OBJECTION

State Significant Development Application No: SSD-10300

Coffs Harbour Cultural and Civic Space

GORDON ST ELEVATION

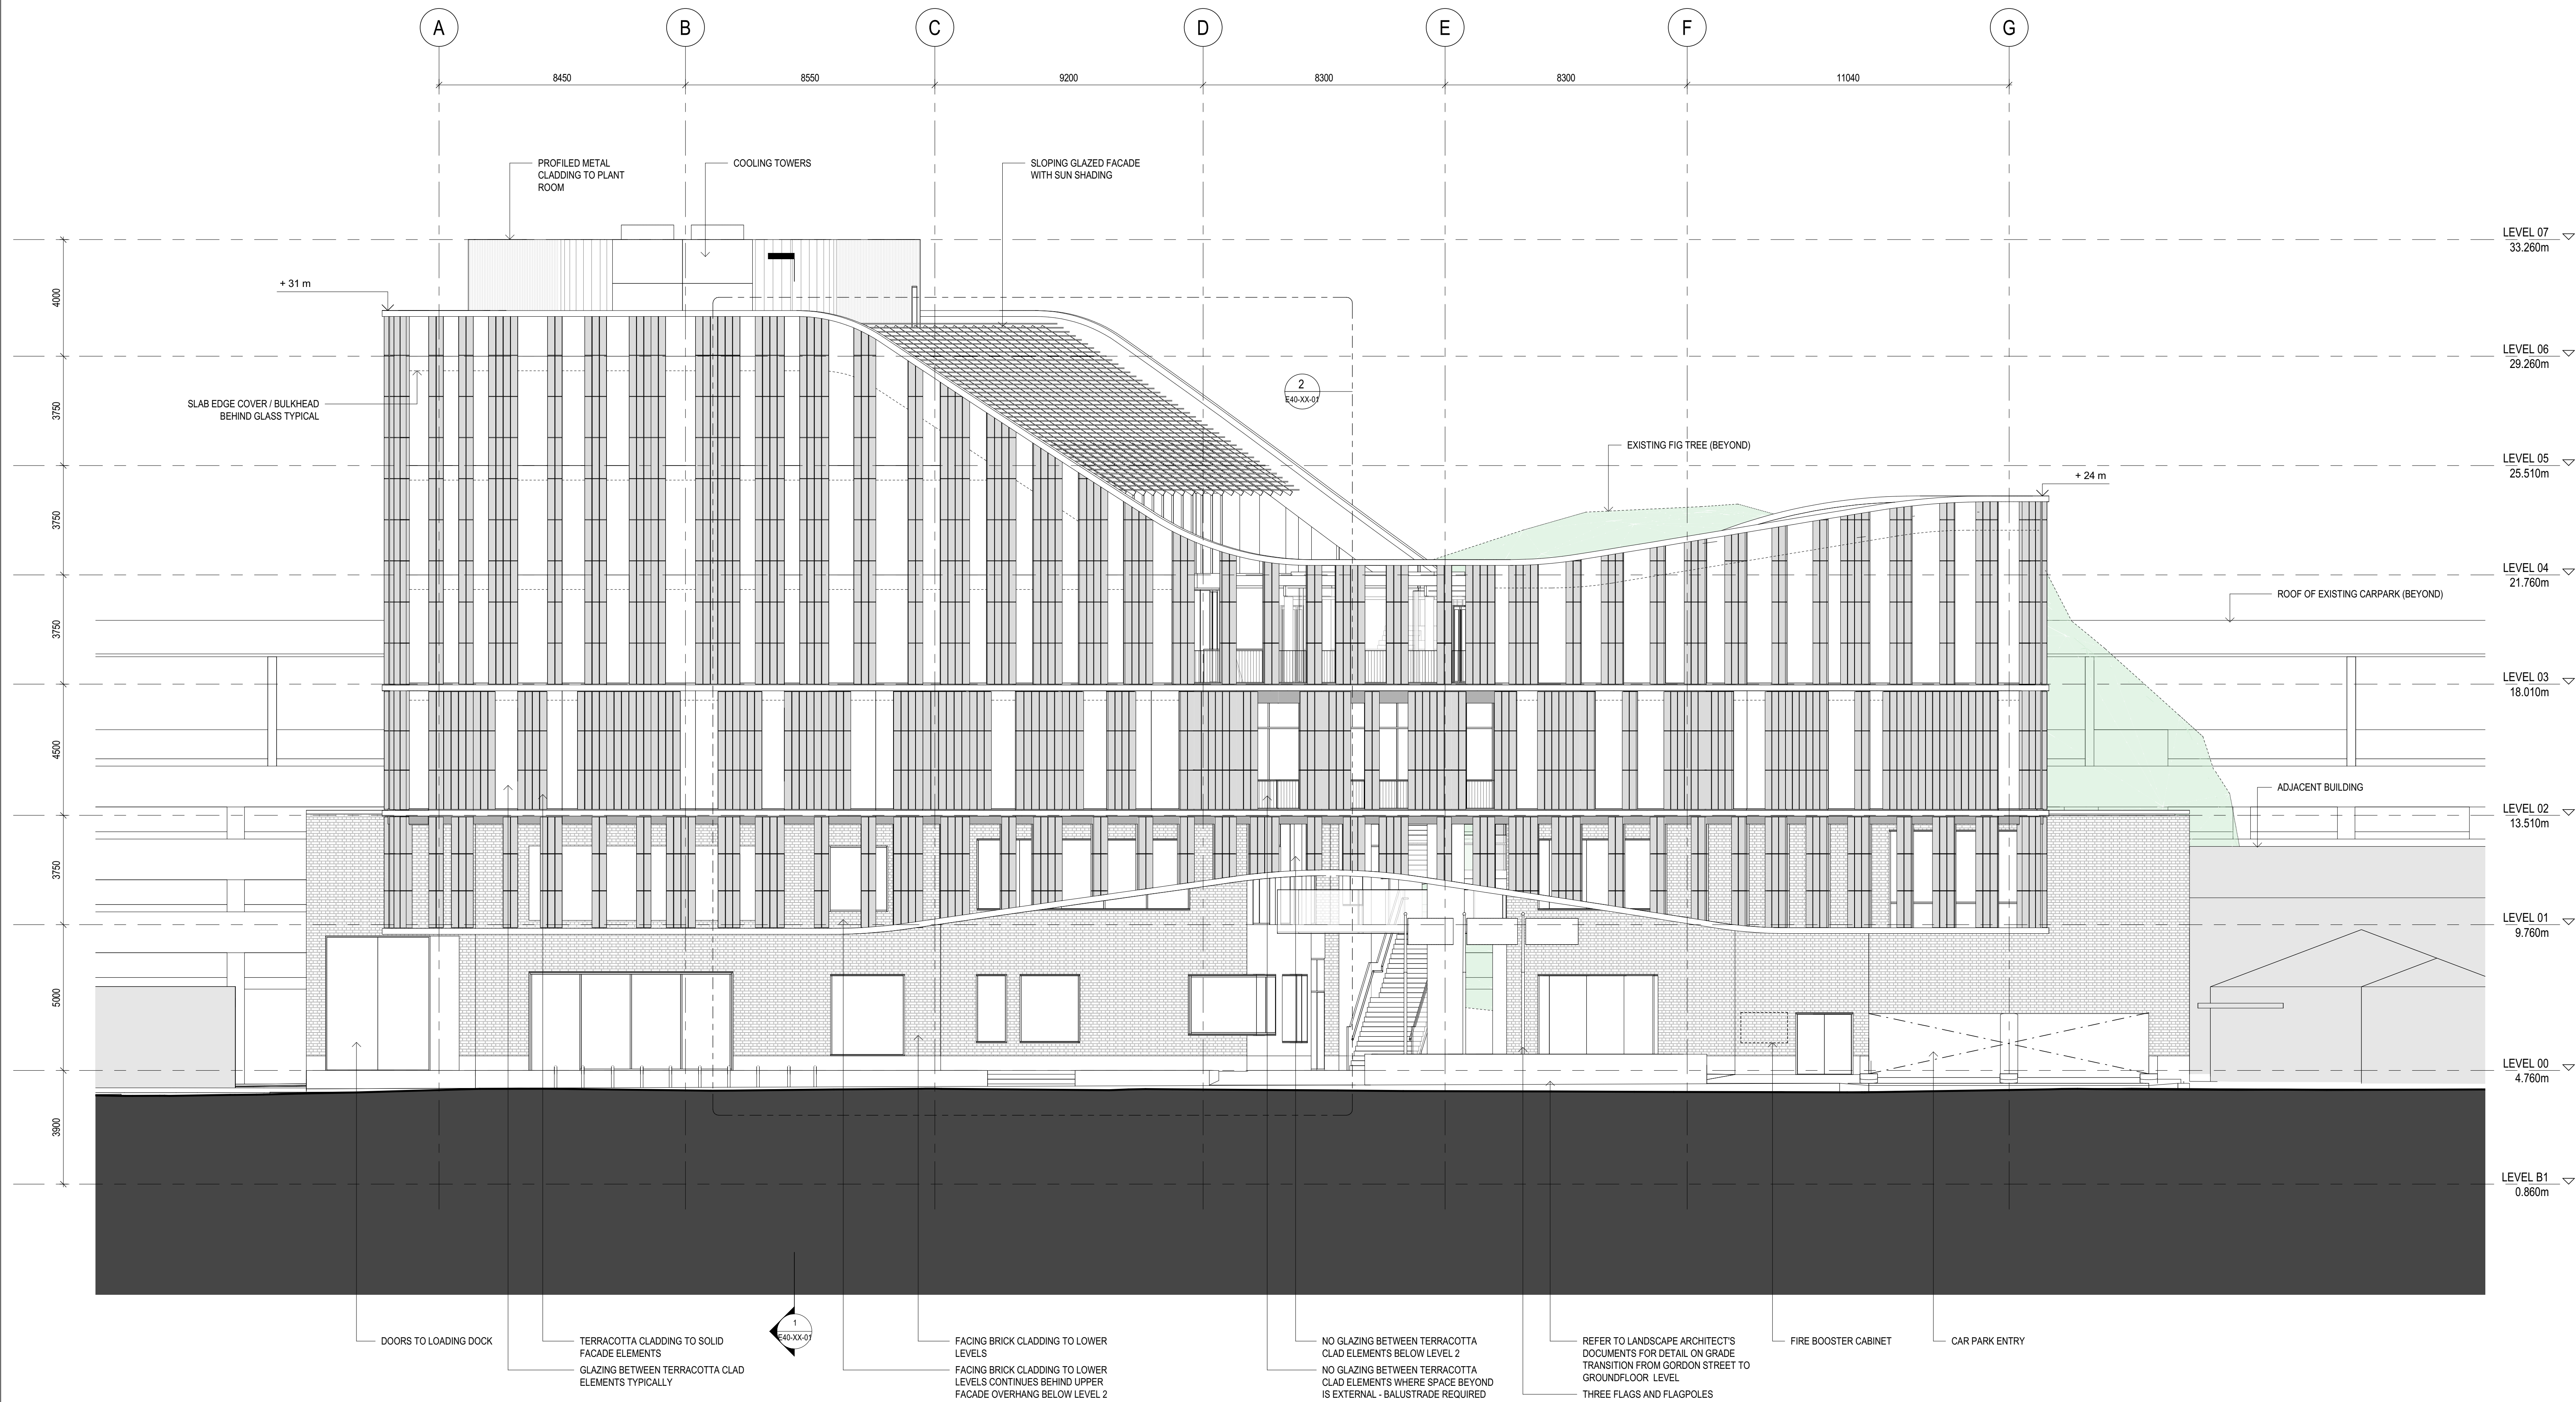
5. The proposed building is out of context in the street with no regard to scale, existing street setbacks, design and general form of adjoining buildings.

SECTION N-S

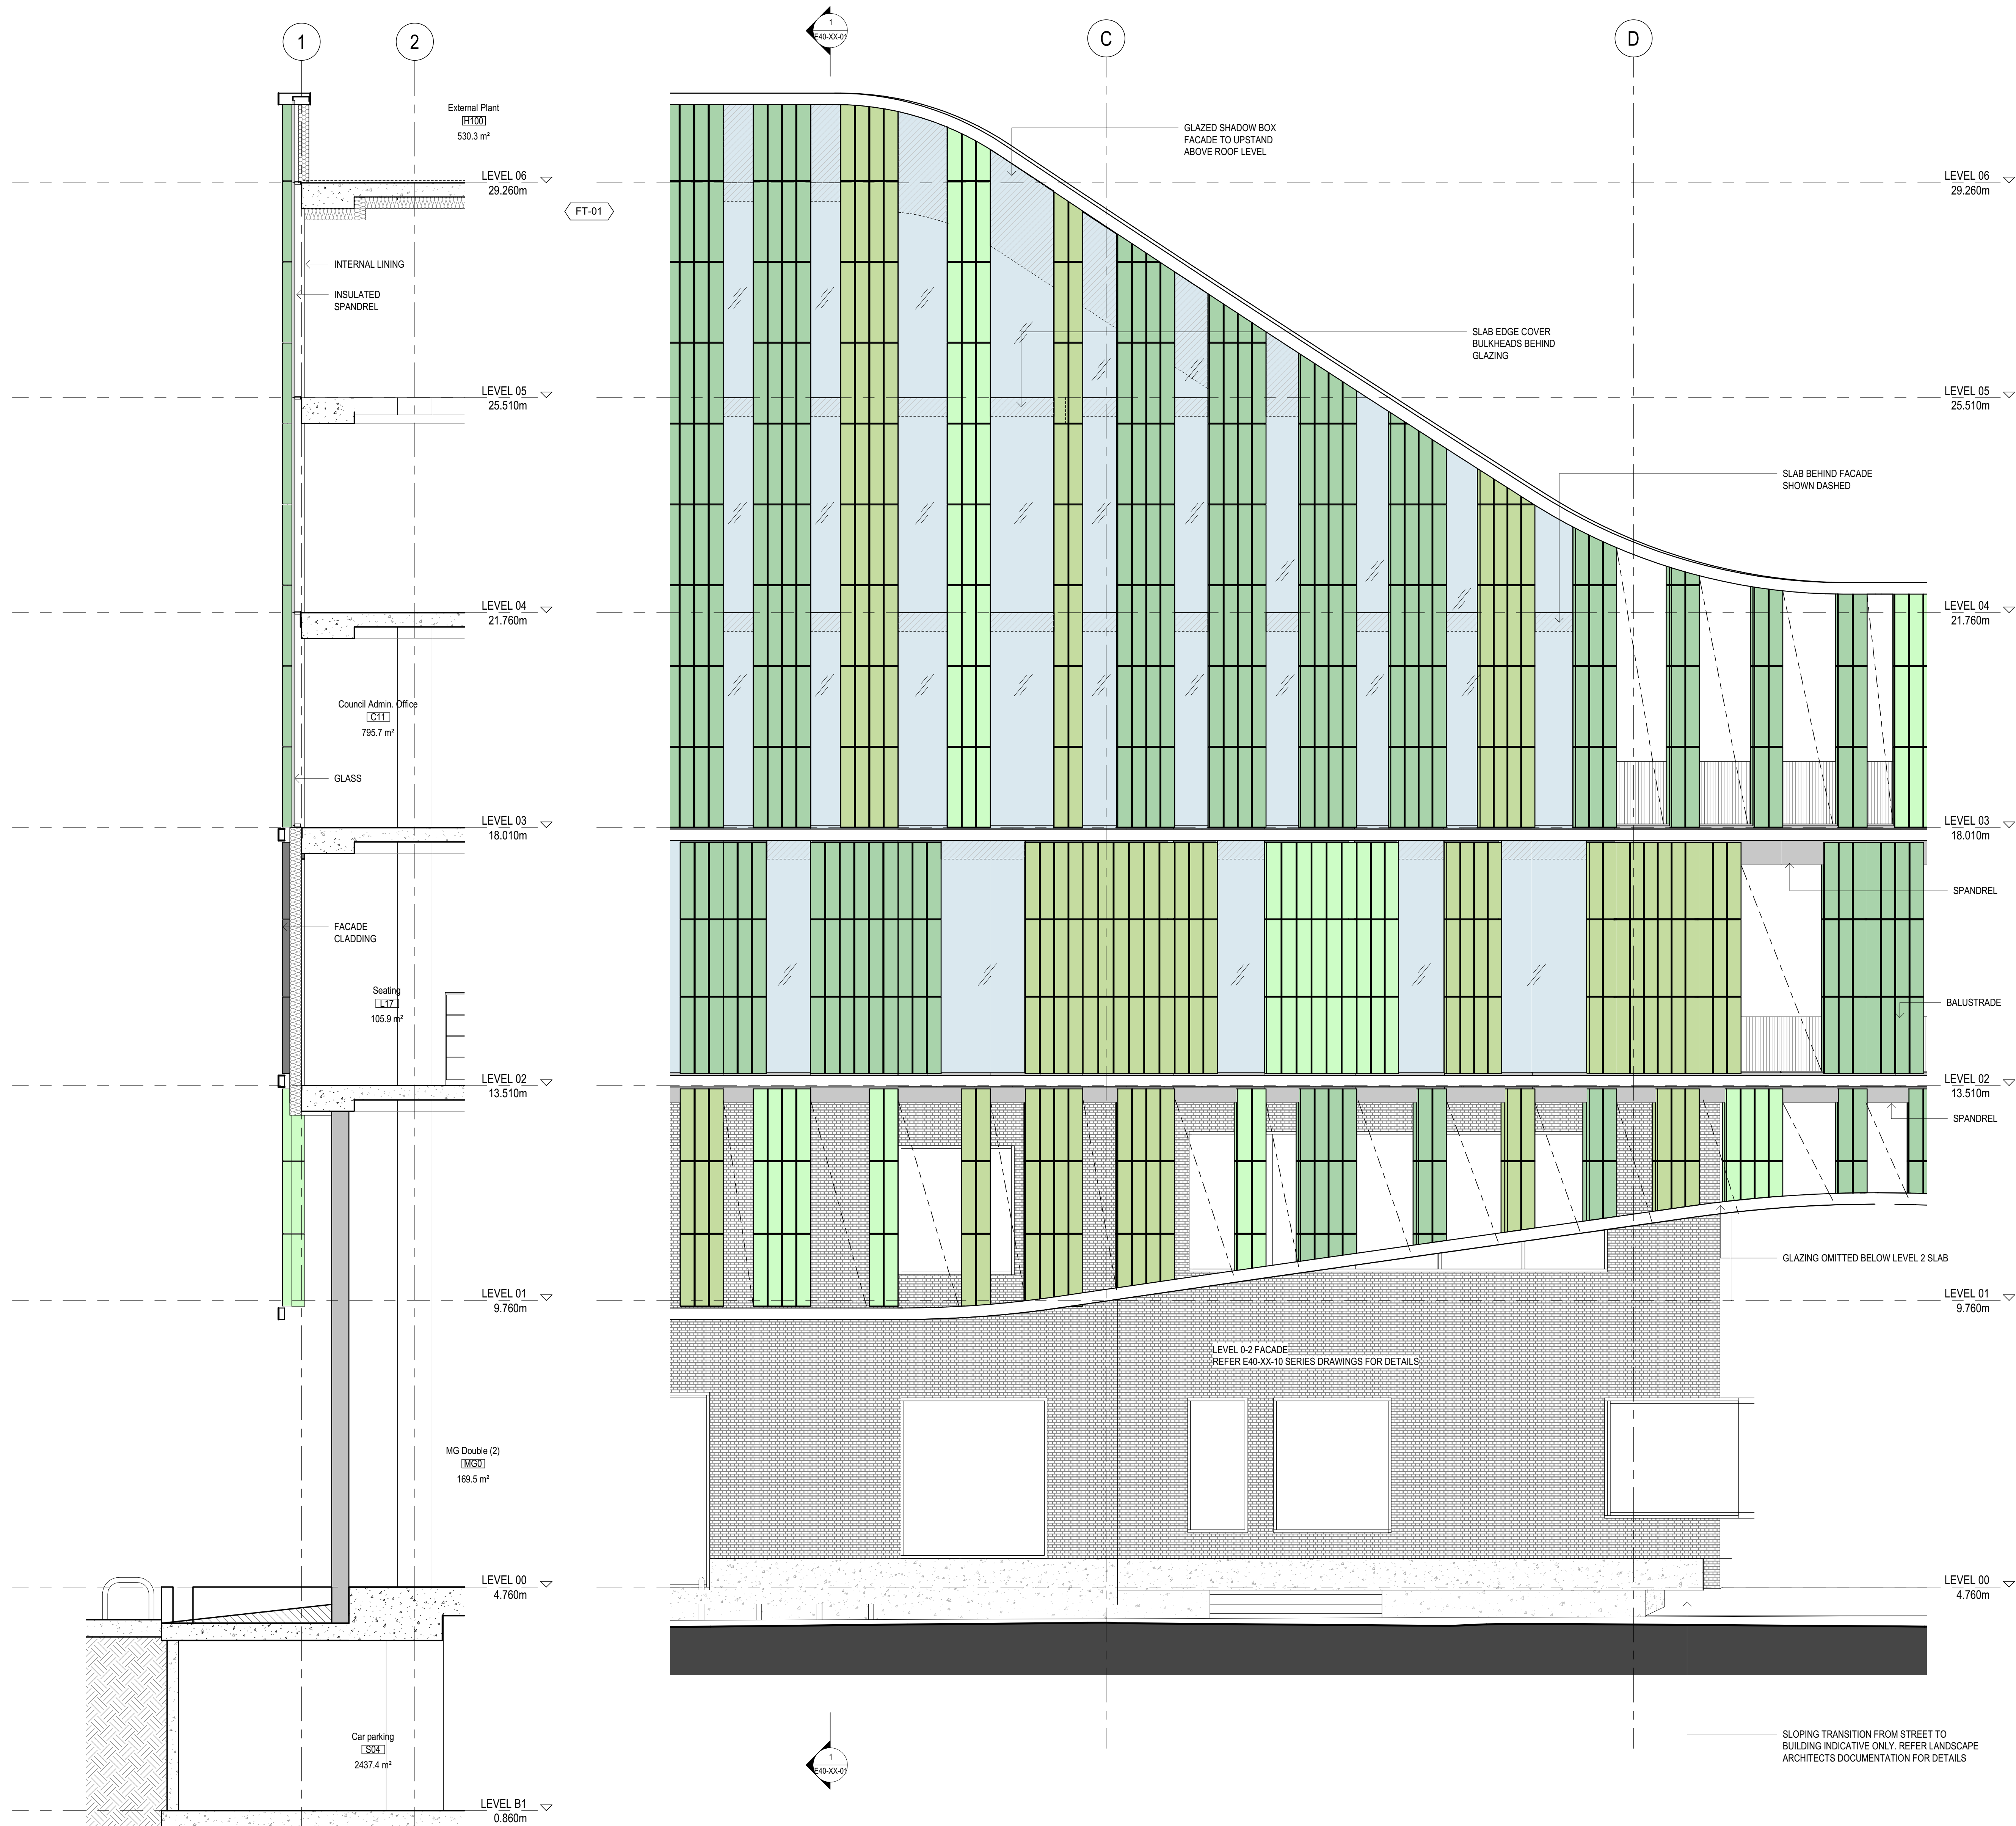
7. As a public building it fails to provide sufficient climate protection for pedestrians during storms and summer sun.
8. The building exceeds the height restriction of 28m set down in Council's own planning controls. Council's argument for variation is not satisfactorily justified and is not consistent with the objectives of the Environmental Planning and Assessment Act 1979, which requires the "the orderly and economic use and development of land". Council should not receive preferential treatment.
